# Longridge Town Council

Following a recent meeting of Longridge Town Council I am directed to inform you of the Council's comments as follows:

| Application No.                                                                                                                                                                                                                             | Location                                                |
|---------------------------------------------------------------------------------------------------------------------------------------------------------------------------------------------------------------------------------------------|---------------------------------------------------------|
| 3/2012/0259                                                                                                                                                                                                                                 | Seven Acre Cottage, Forty Acre Lane, Longridge, PR3 2TY |
| New vehicle and pedestrian site access drive.

site plan. scale: 1:500

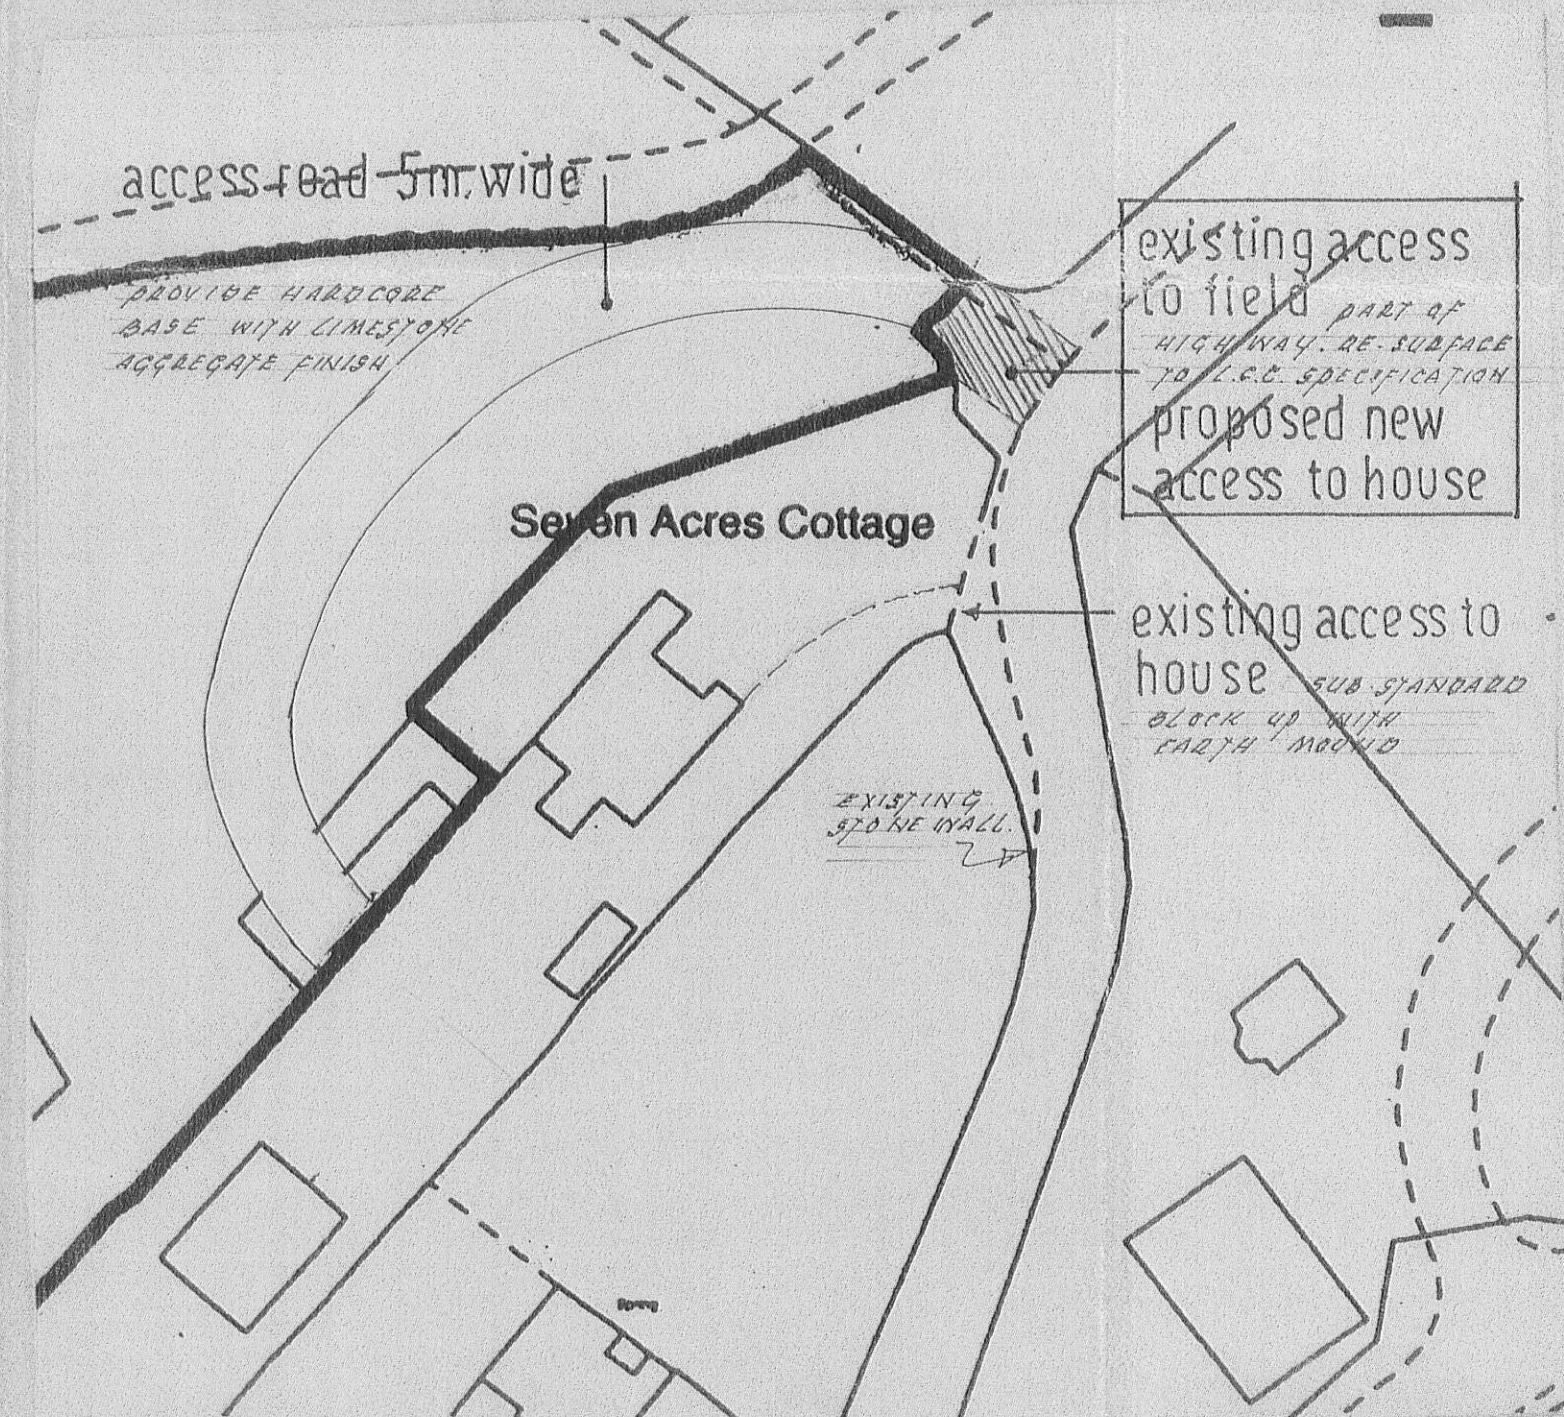
| Application No.                                                                                                                                                                                                                             | Location                                                |
|---------------------------------------------------------------------------------------------------------------------------------------------------------------------------------------------------------------------------------------------|---------------------------------------------------------|
| Councillors <b>object</b> to this application on the basis of concerns for highways safety, as this will establish an unnecessary second access point within fifty yards of a dangerous 'S' bend on this road designated as a 'quiet lane'. |                                                         |
